Rezoning Transportation Analysis

Petition Number: 2020-166

General Location Identifier: Tax ID: 09110504

Date	Description
11-30-20	First Review (EL)
12-28-20	Second Review (KP)
01-26-21	Third Review (EL)

SCHEMATIC SITE PLAN

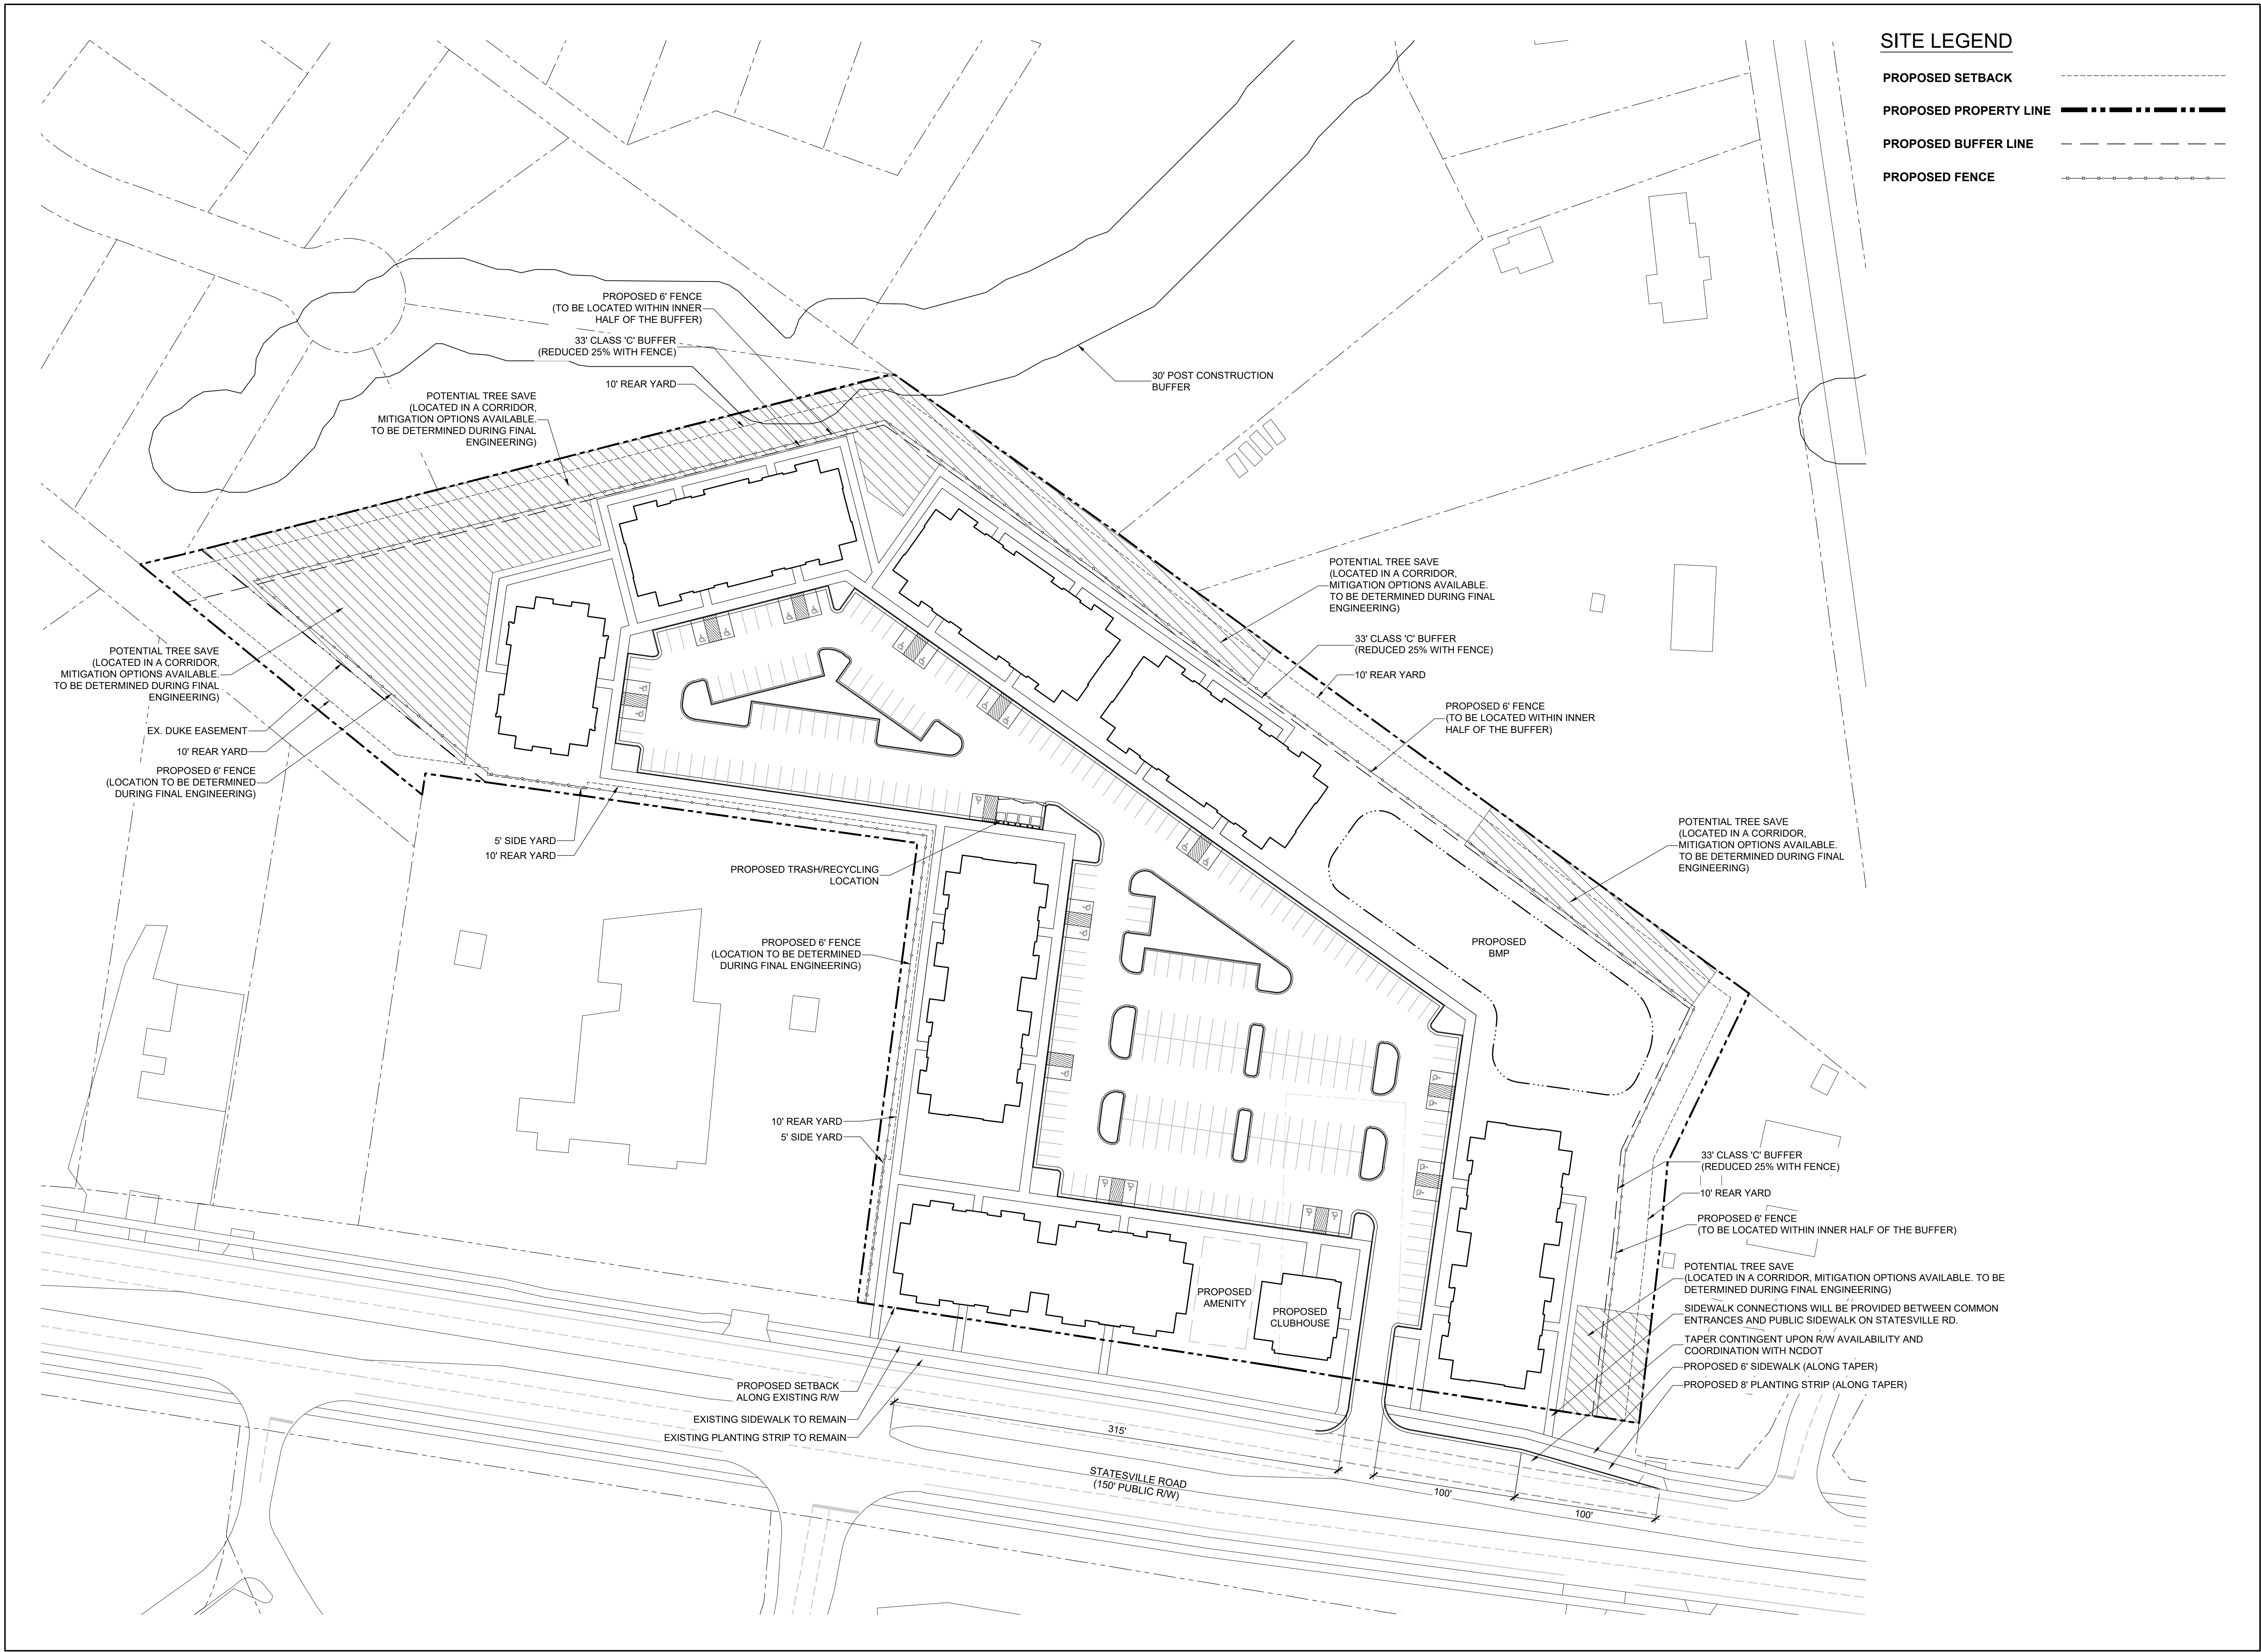
- ~~3. Revise the site plan and conditional note(s) to relocate the proposed access on Statesville Road approximately 315 feet to the existing left-turn lane taper on Statesville Road. Provide a northbound right-turn lane with 100-foot storage and 100-foot taper at the relocated access on Statesville Road, as required by NCDOT.~~

Update to Comment as a result of the 12-15-2020 Site Plan: Please include the taper and storage lengths of the turn lane within a conditional note and on the site plan. Also, please show the striping on Statesville Road.

The site is located on a State-maintained major thoroughfare road [Statesville Road]. The petitioner has coordinated the proposed access off Statesville Road with NCDOT and will install a right-turn lane in accordance with NCDOT standards. The existing streetscape along Statesville Road contains an 8-foot planting strip, 6-foot sidewalk, and an on-street bike facility. All CDOT comments have been resolved.
